Application Ref:	3/2025/0848			 Ribble Valley Borough Council www.ribblevalley.gov.uk				
Date Inspected:	06/11/2025	Site Notice:	06/11/2025					
Officer:	MC							
DELEGATED ITEM FILE REPORT:					APPROVAL

Development Description:	Reserved matters application relating to appearance, landscaping, layout and scale following outline planning permission 3/2025/0289.
Site Address/Location:	Thornley Hall Farm, Up Bedlam Road, Thornley, PR3 2TN

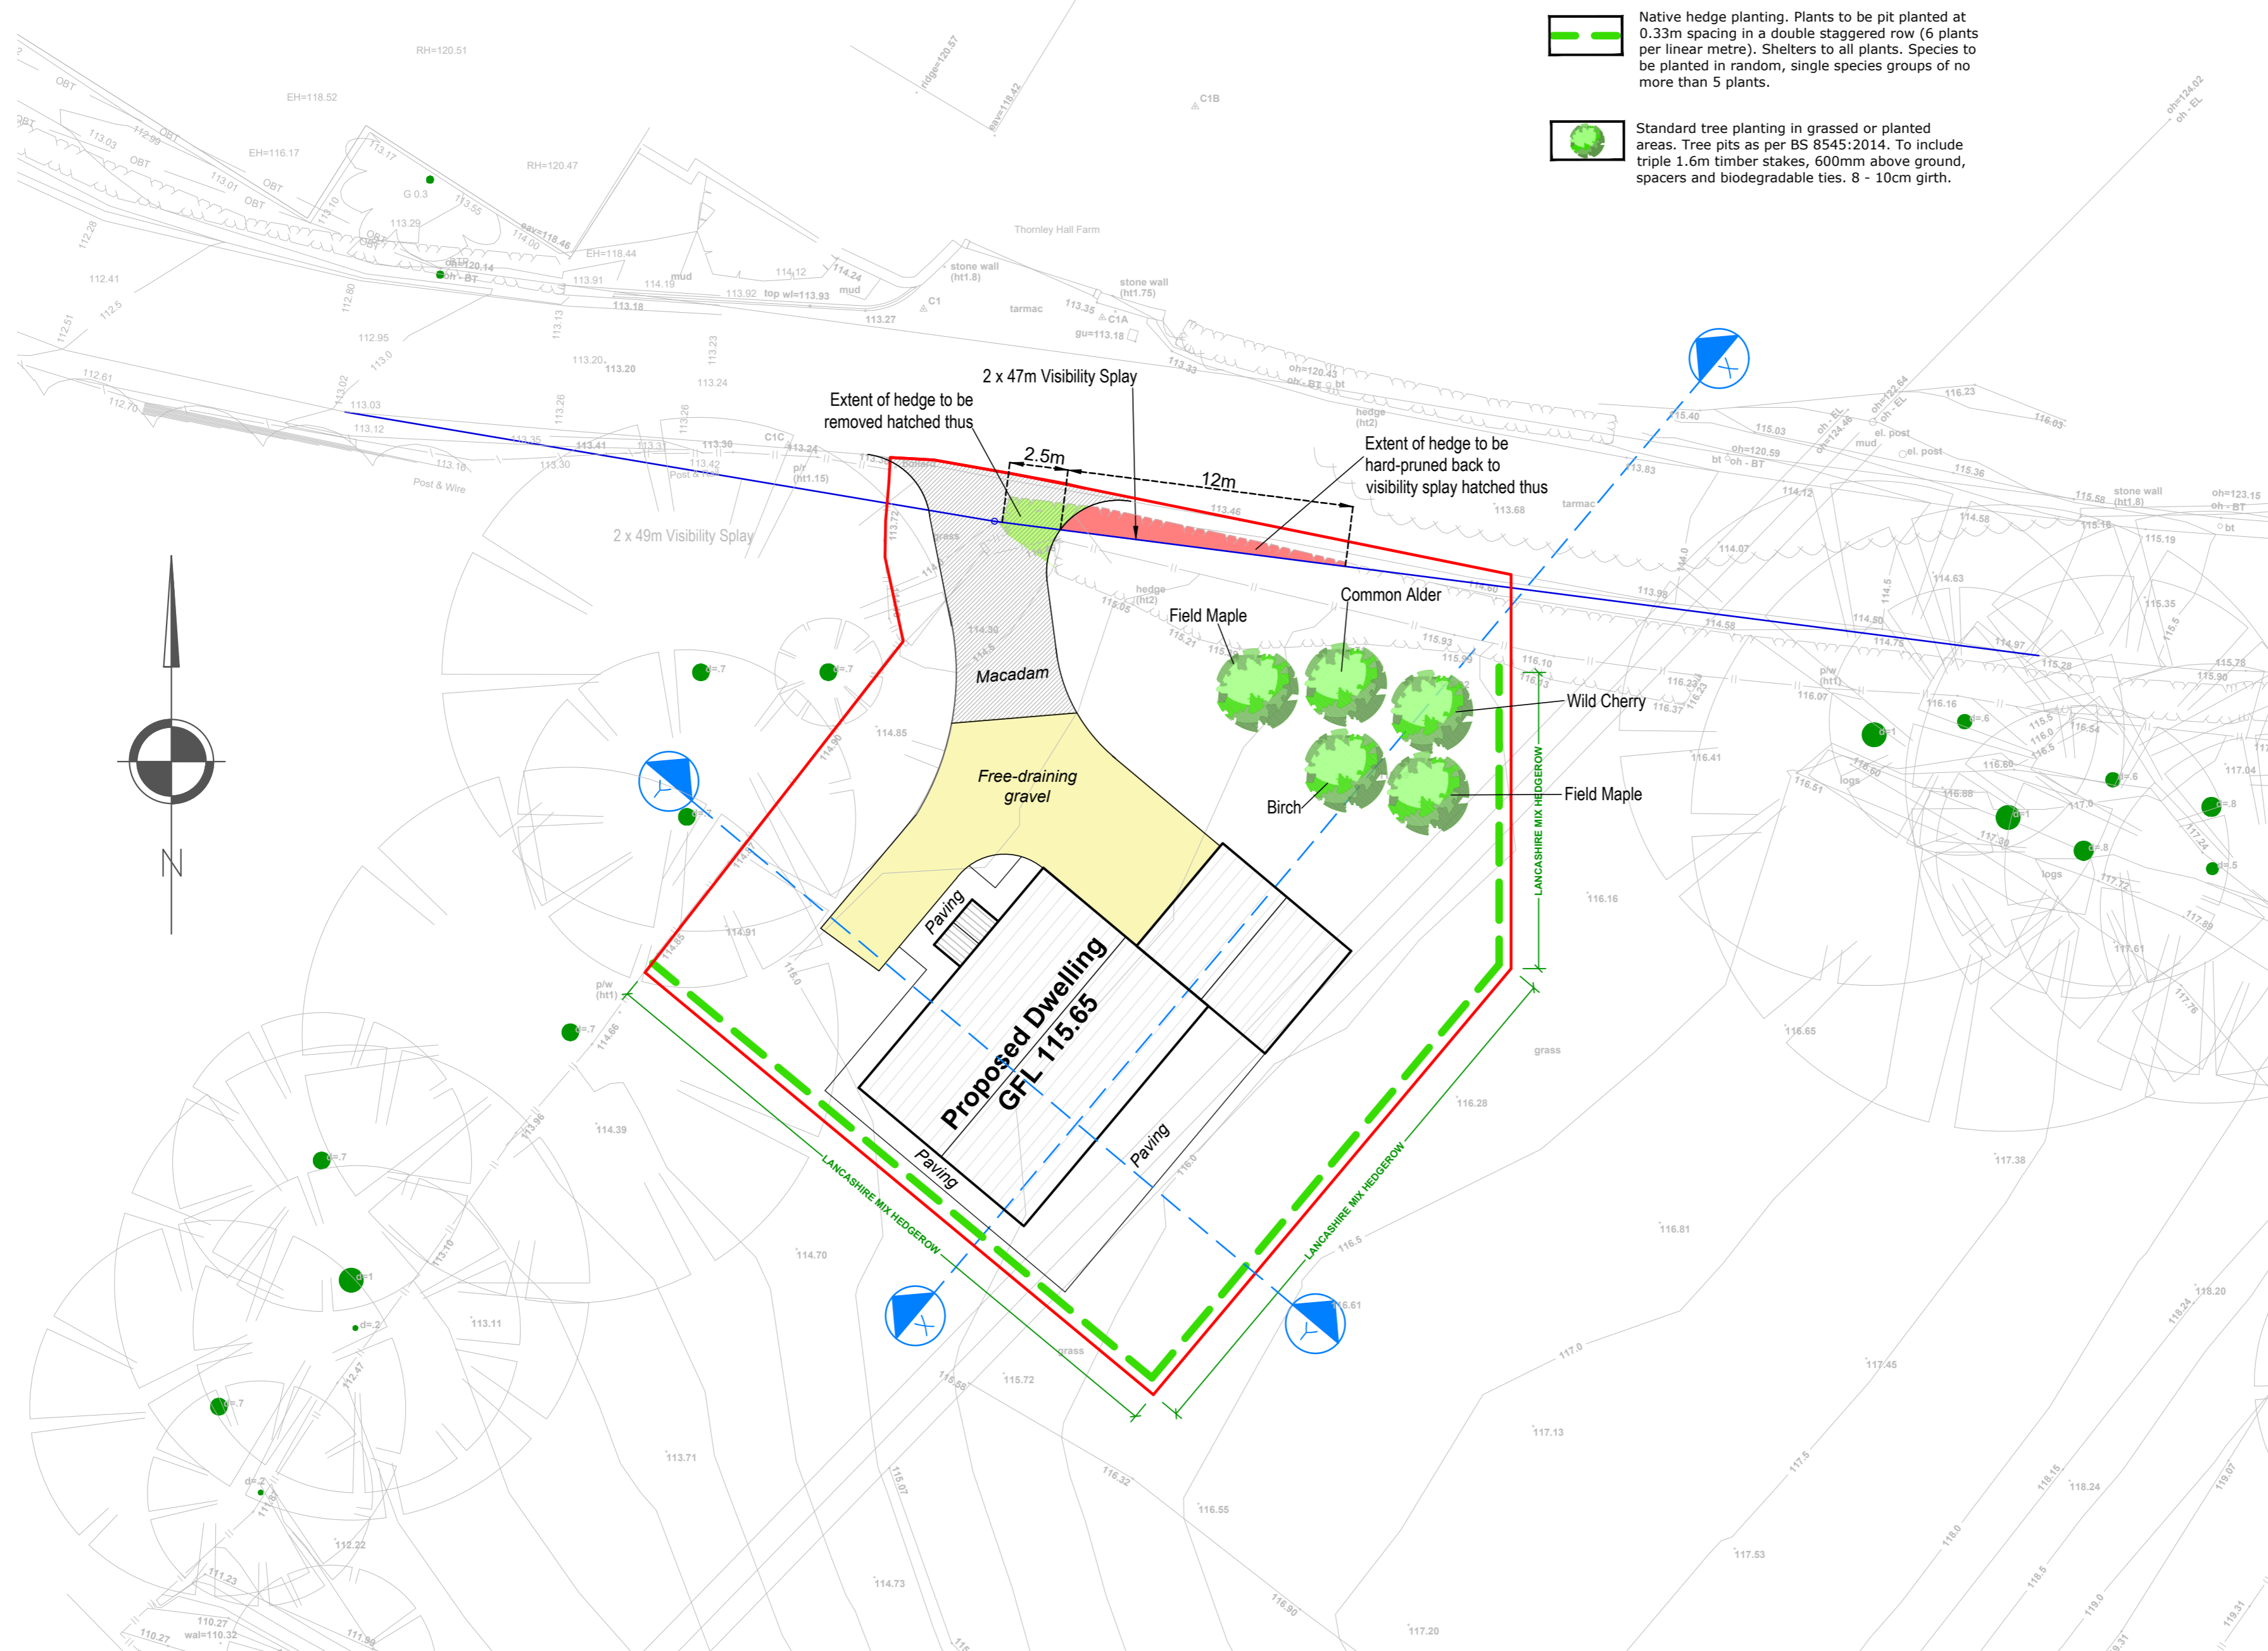
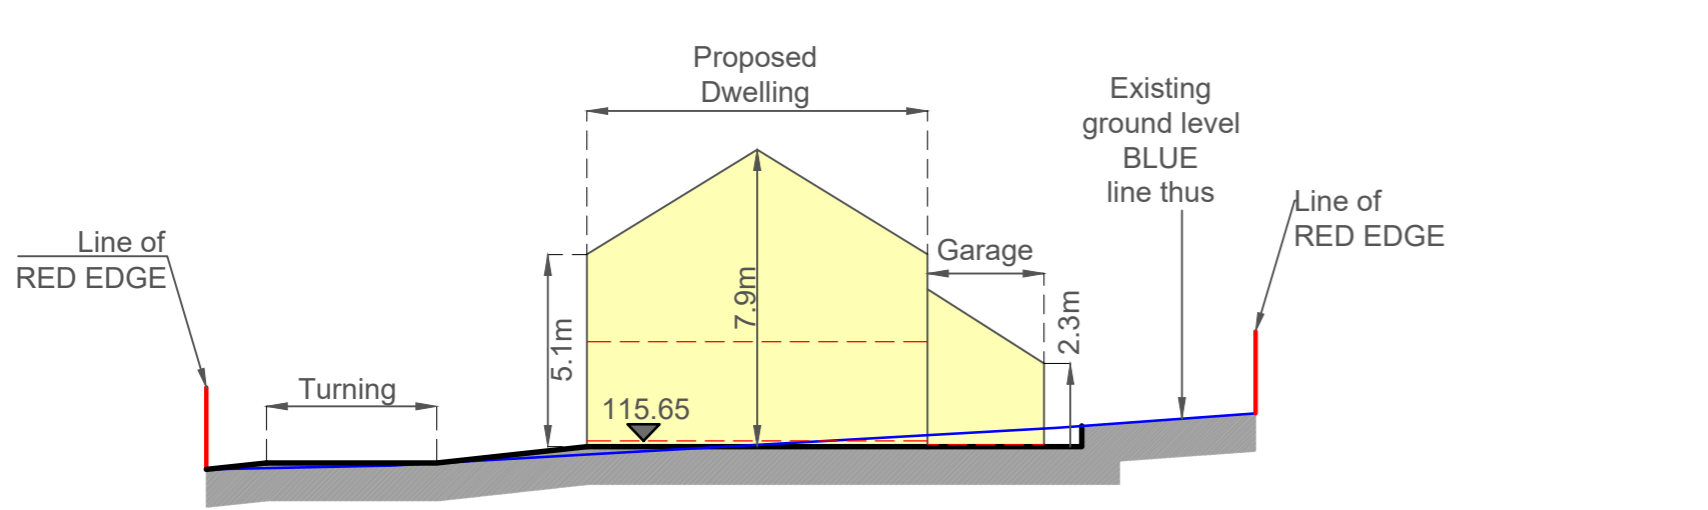
The Local Highway Authority have provided comments on the scheme and they note that drawing Air/1164/3706/03 Revision A (now updated to Rev B to show additional planting), shows that a visibility of 47m can be achieved to the East and 49m can be achieved West. The drawing shows a section of vegetation that would need to be reduced and/or removed in order to achieve the visibility splay. The site plan, drawing Air/1164/3706/03 Revision B, also shows that the access is to be surfaced in a hard-standing material for at least the first 10m into the site.

The Countryside Officer has commented that if the relatively short section of hedge shown to be cut back or coppiced and is not destroyed, it will rejuvenate and can be managed accordingly. However, as this hedgerow removal is required for visibility, it is required to be removed. The existing hedge would remain in situ and alternative landscaping has been secured which includes the planting of 3 no. additional trees, which will help to screen the development in the long term.

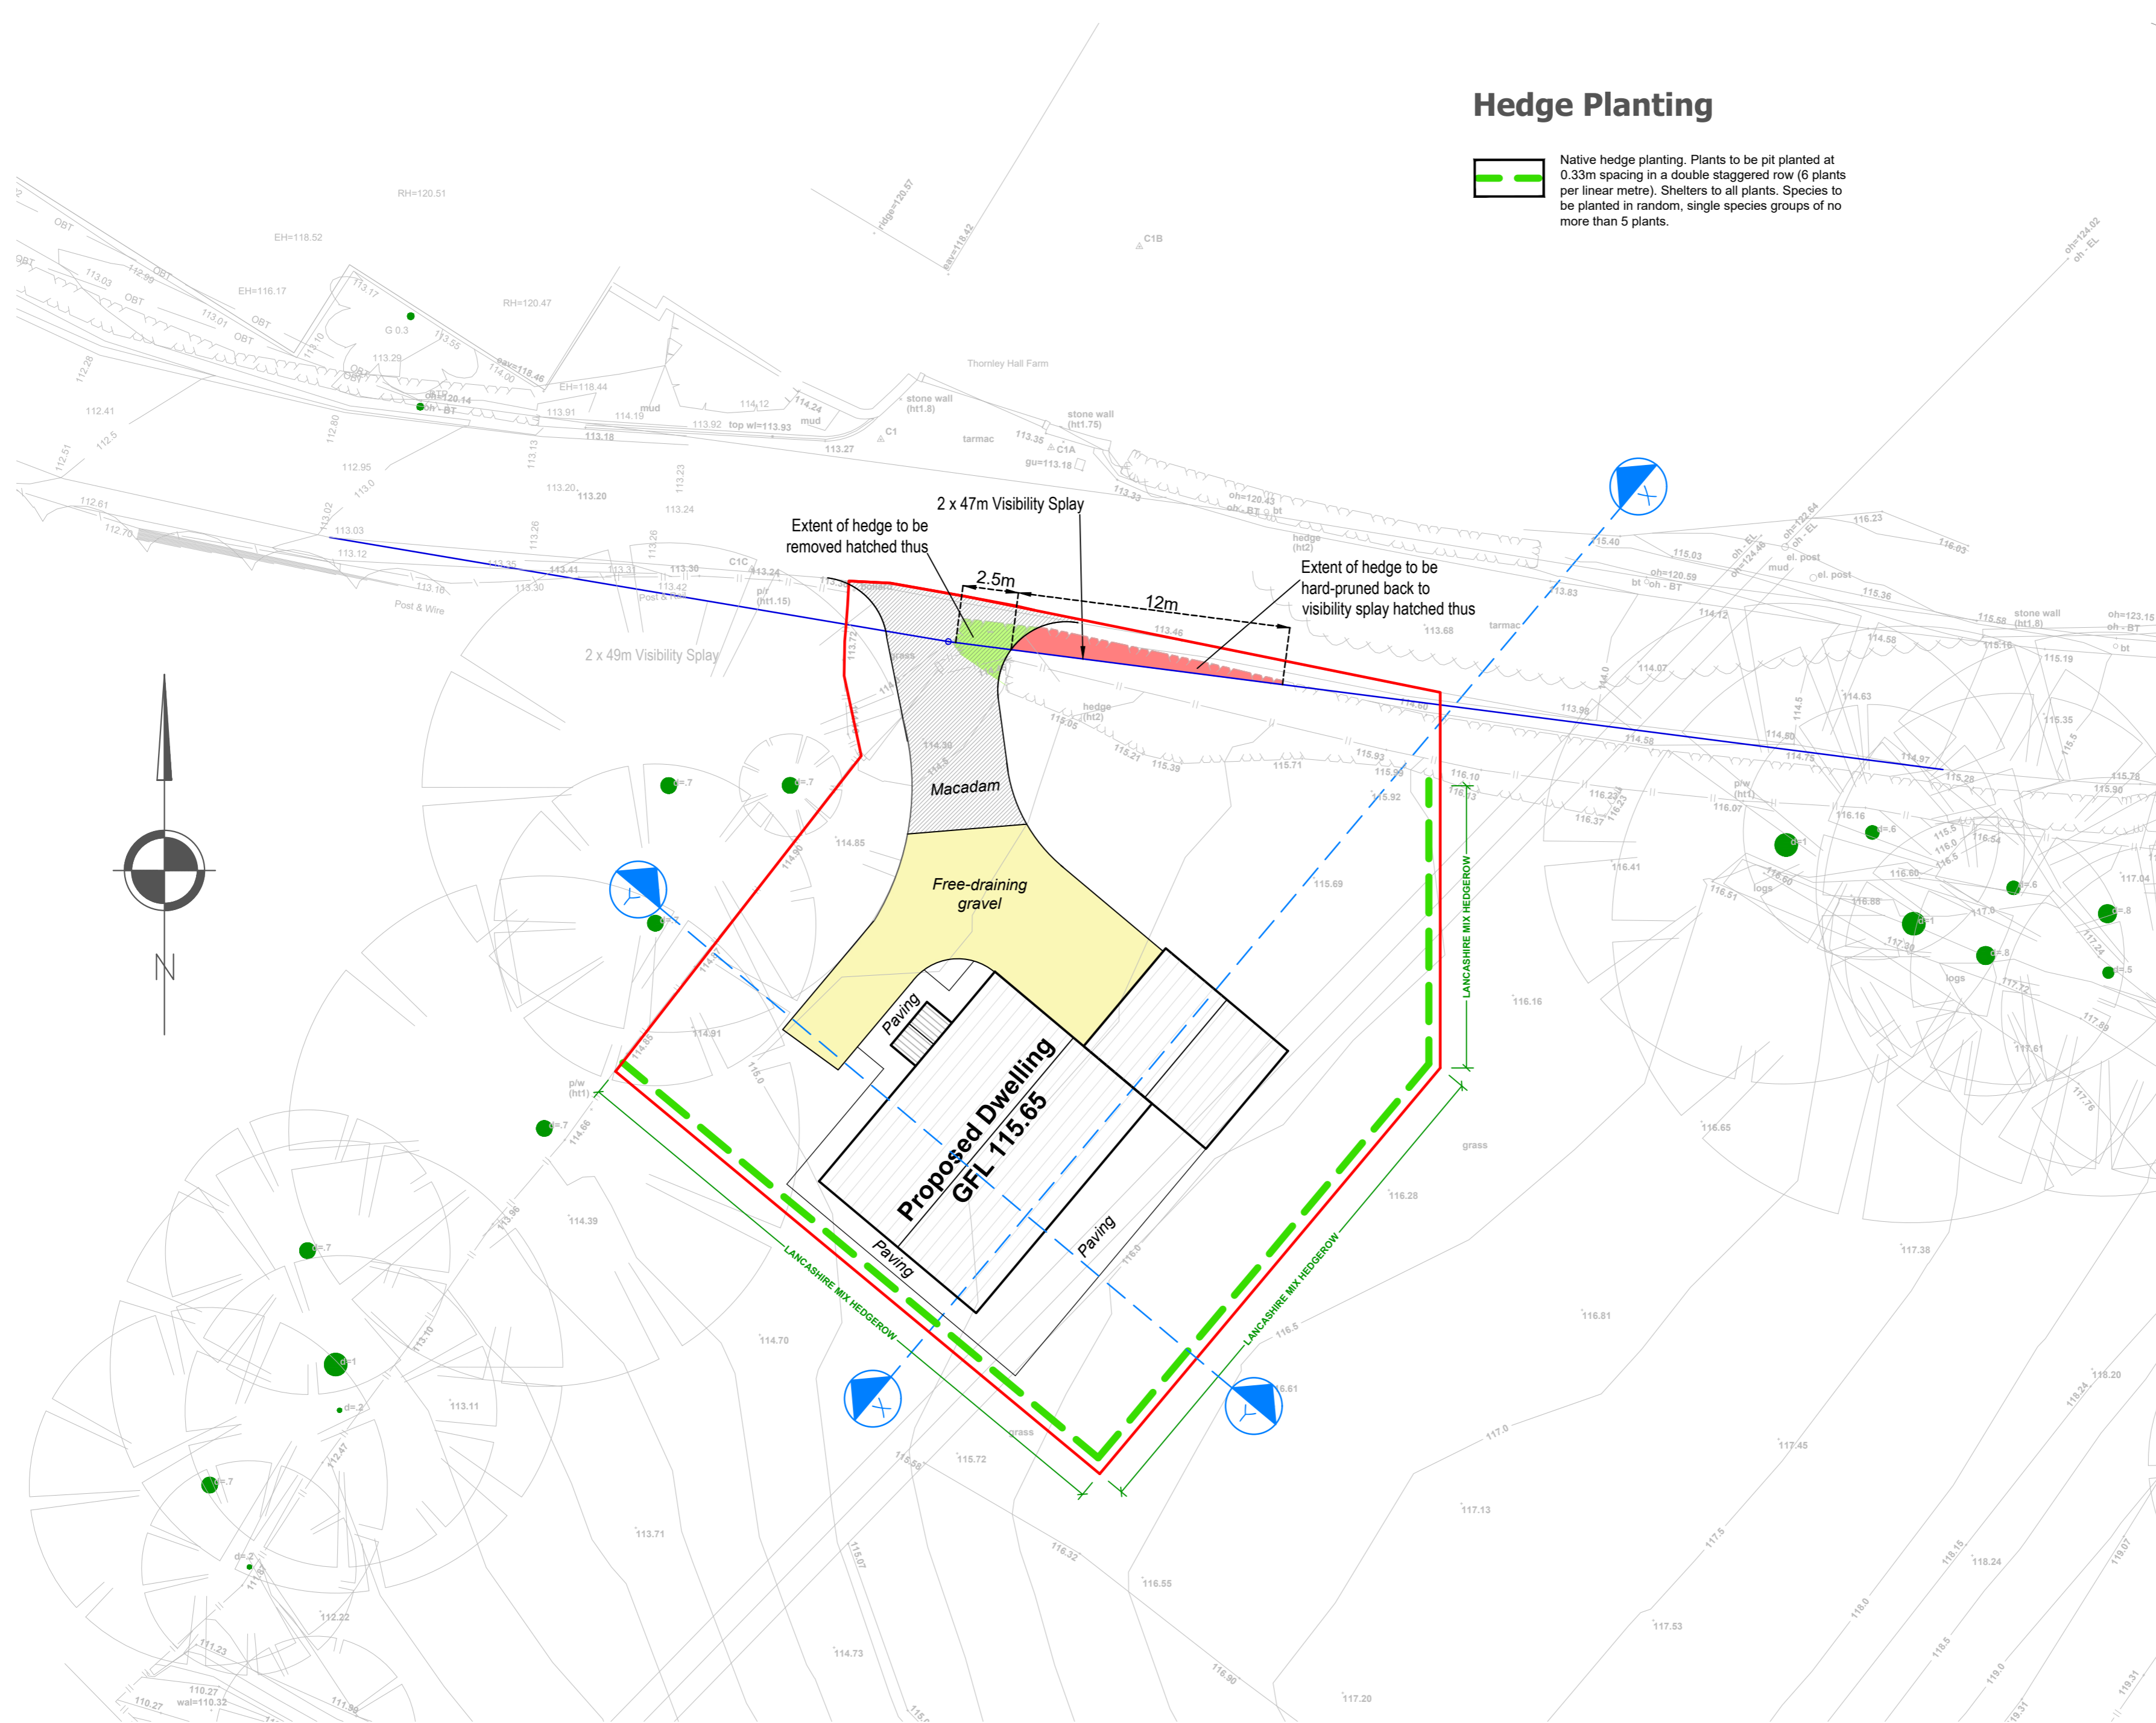
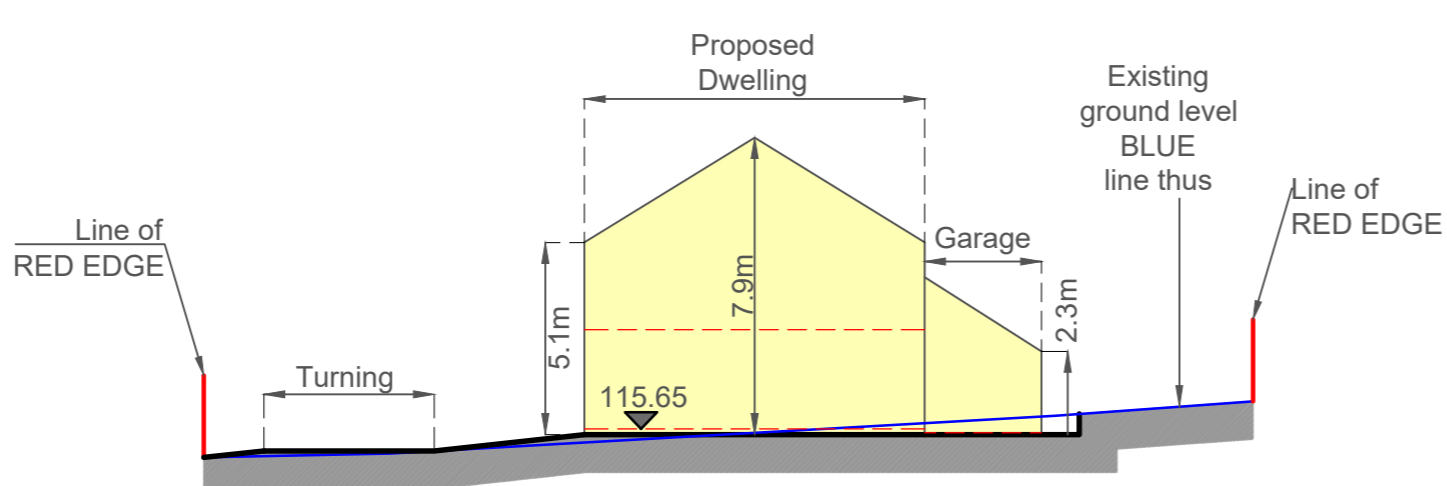
The area inside the garage where a car is shown to be parked, would not meet the internal size requirements which should be approximately 3m x 6m. However, the driveway could provide adequate parking for up to 3 no. vehicles and allow room to turn. As such, this would not warrant refusal of the application.
